Your ref: SSD 5175 Mod 3 &
SSD 8588
File no: MC-12-1769

**Projects: SSD 5175 Mod 3 Eastern Creek Business Hub s96(1A) to amend
the total Gross Floor Area
SSD 8588 for the construction of a retail centre on approved Lot 2
(Stage 1)**

Re: Response from Council

**12.5m LARGE RIGID VEHICLE  
 SWEEP PATHS**

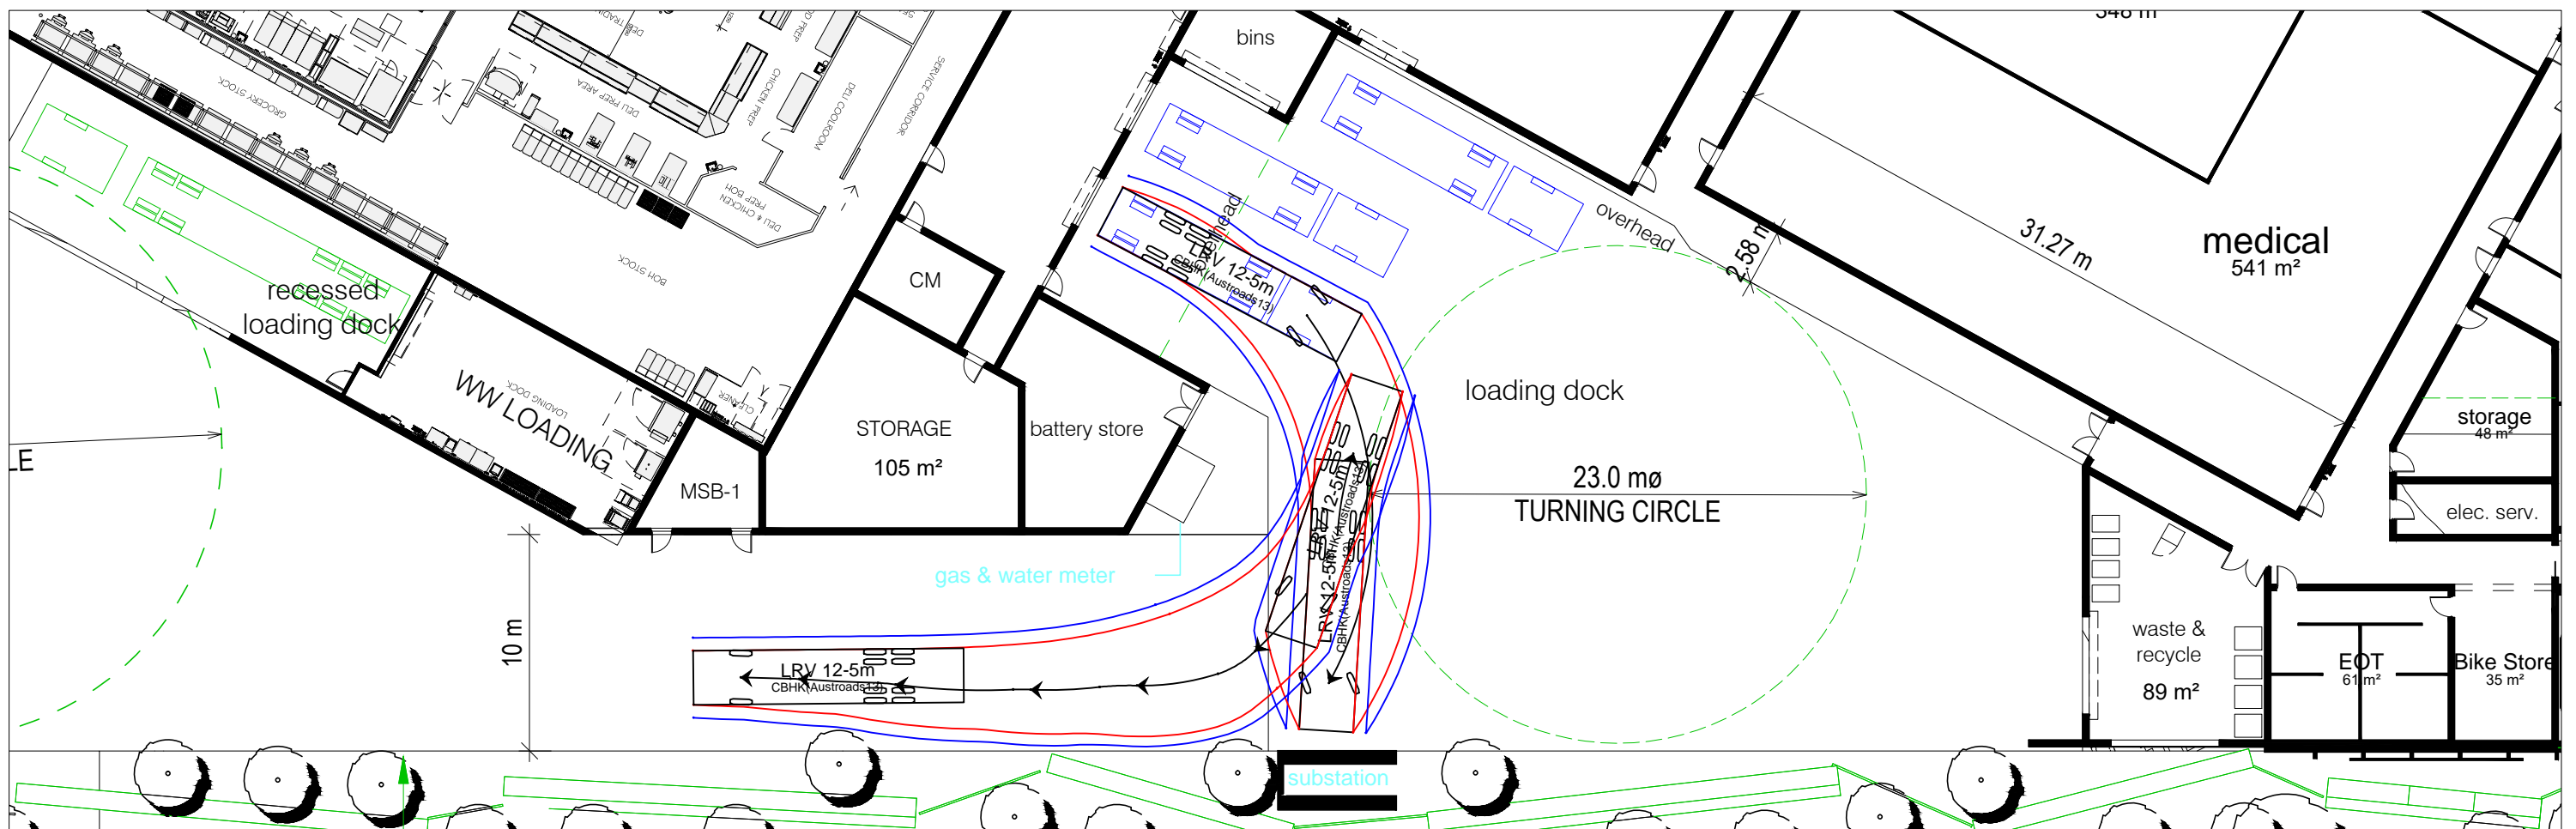
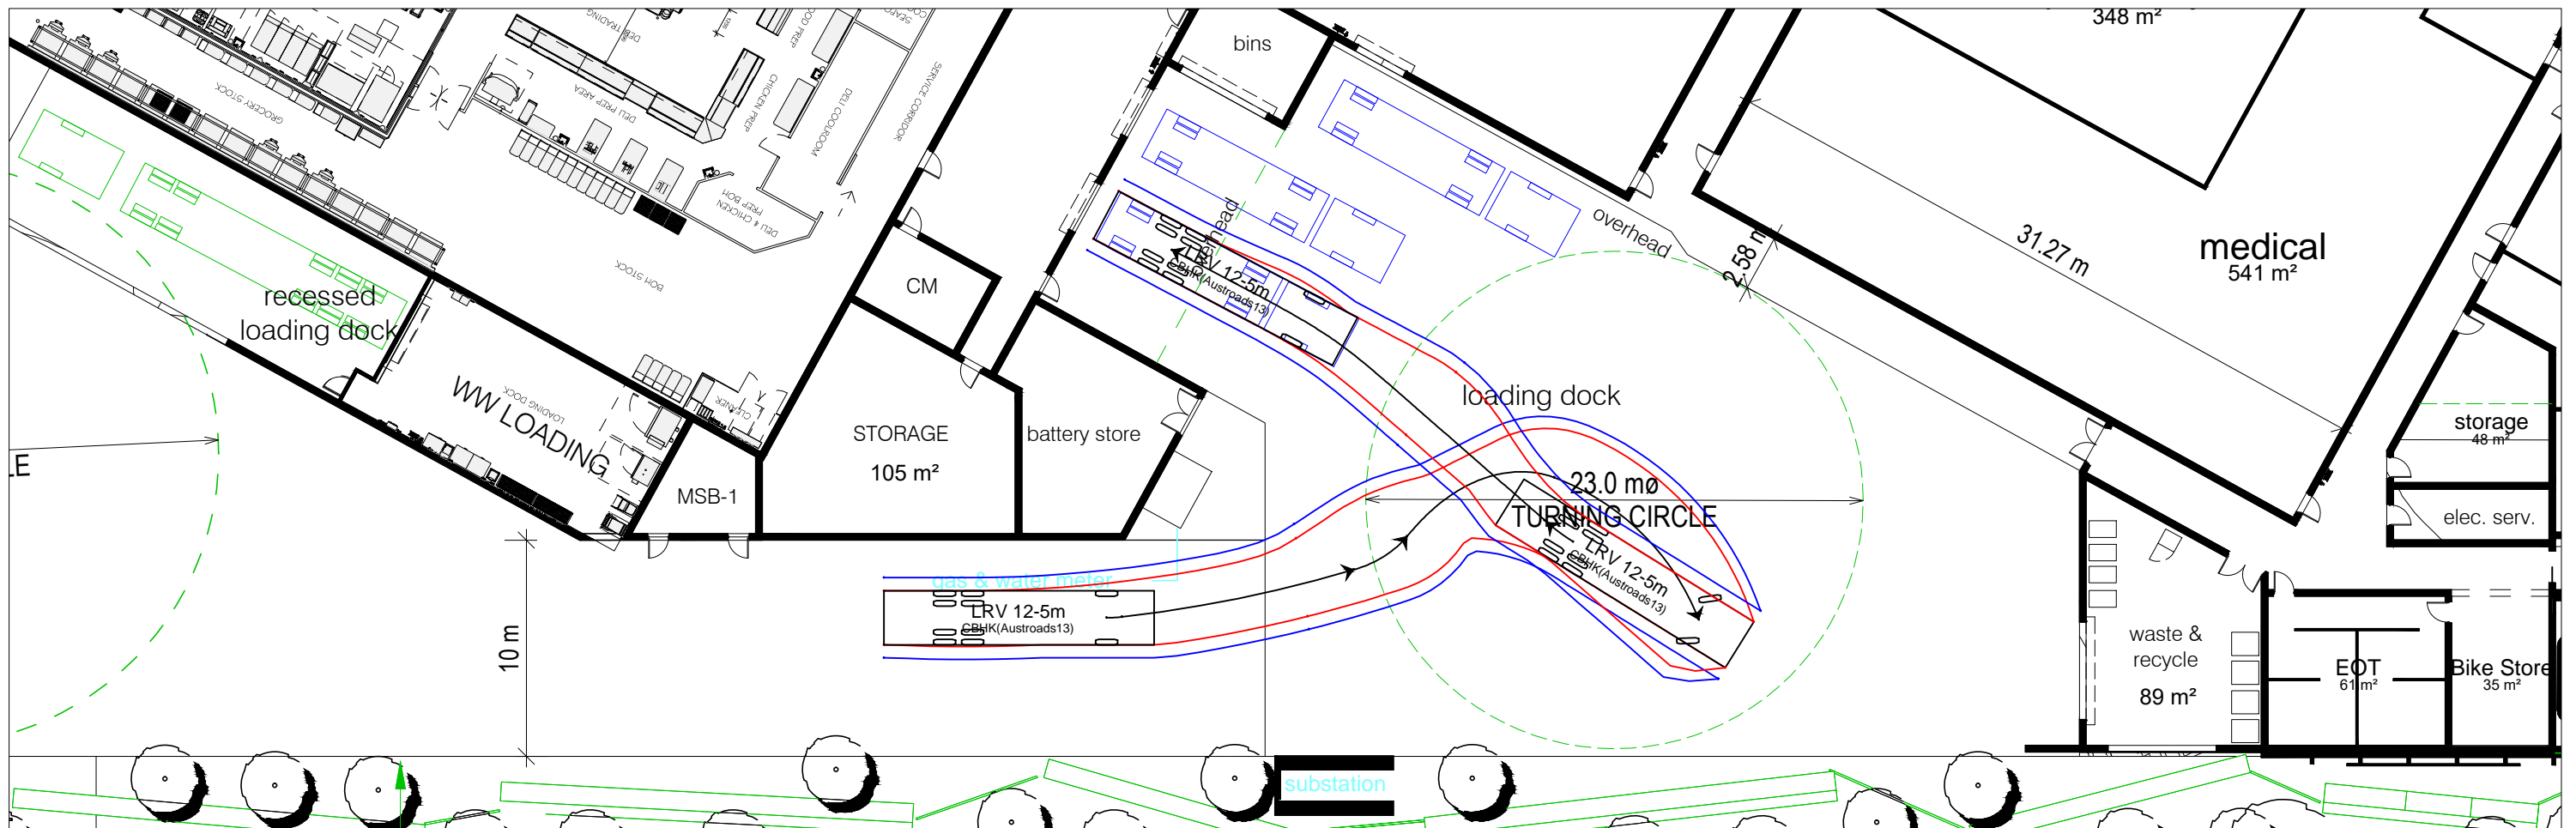
Drainage and Engineering Matters
<p>This item is still being assessed and a response will be provided separately.</p>
Traffic Management Matters
<p>The following comments are provided by Council's Access and Transport Management Section (ATMS):</p> <ol style="list-style-type: none">1. Council's local industrial road is 20.5 m wide which includes a 13.5 m wide carriageway and a 3.5 m wide footway on each side. The proposed 12 m wide carriageway does not comply with Council's DCP requirement and is not supported.2. A turning head in the form of a cul-de-sac with a carriageway radius of 13.5 m is

required at the end of Beggs Road. We do not support a three point turn by a truck on a public road.

1. The Beggs Road carriageway is to have a width of 13.5 m.
2. The end of Beggs Road is required to have a turning head in the form of a cul-de-sac with a carriageway radius of 13.5 m.
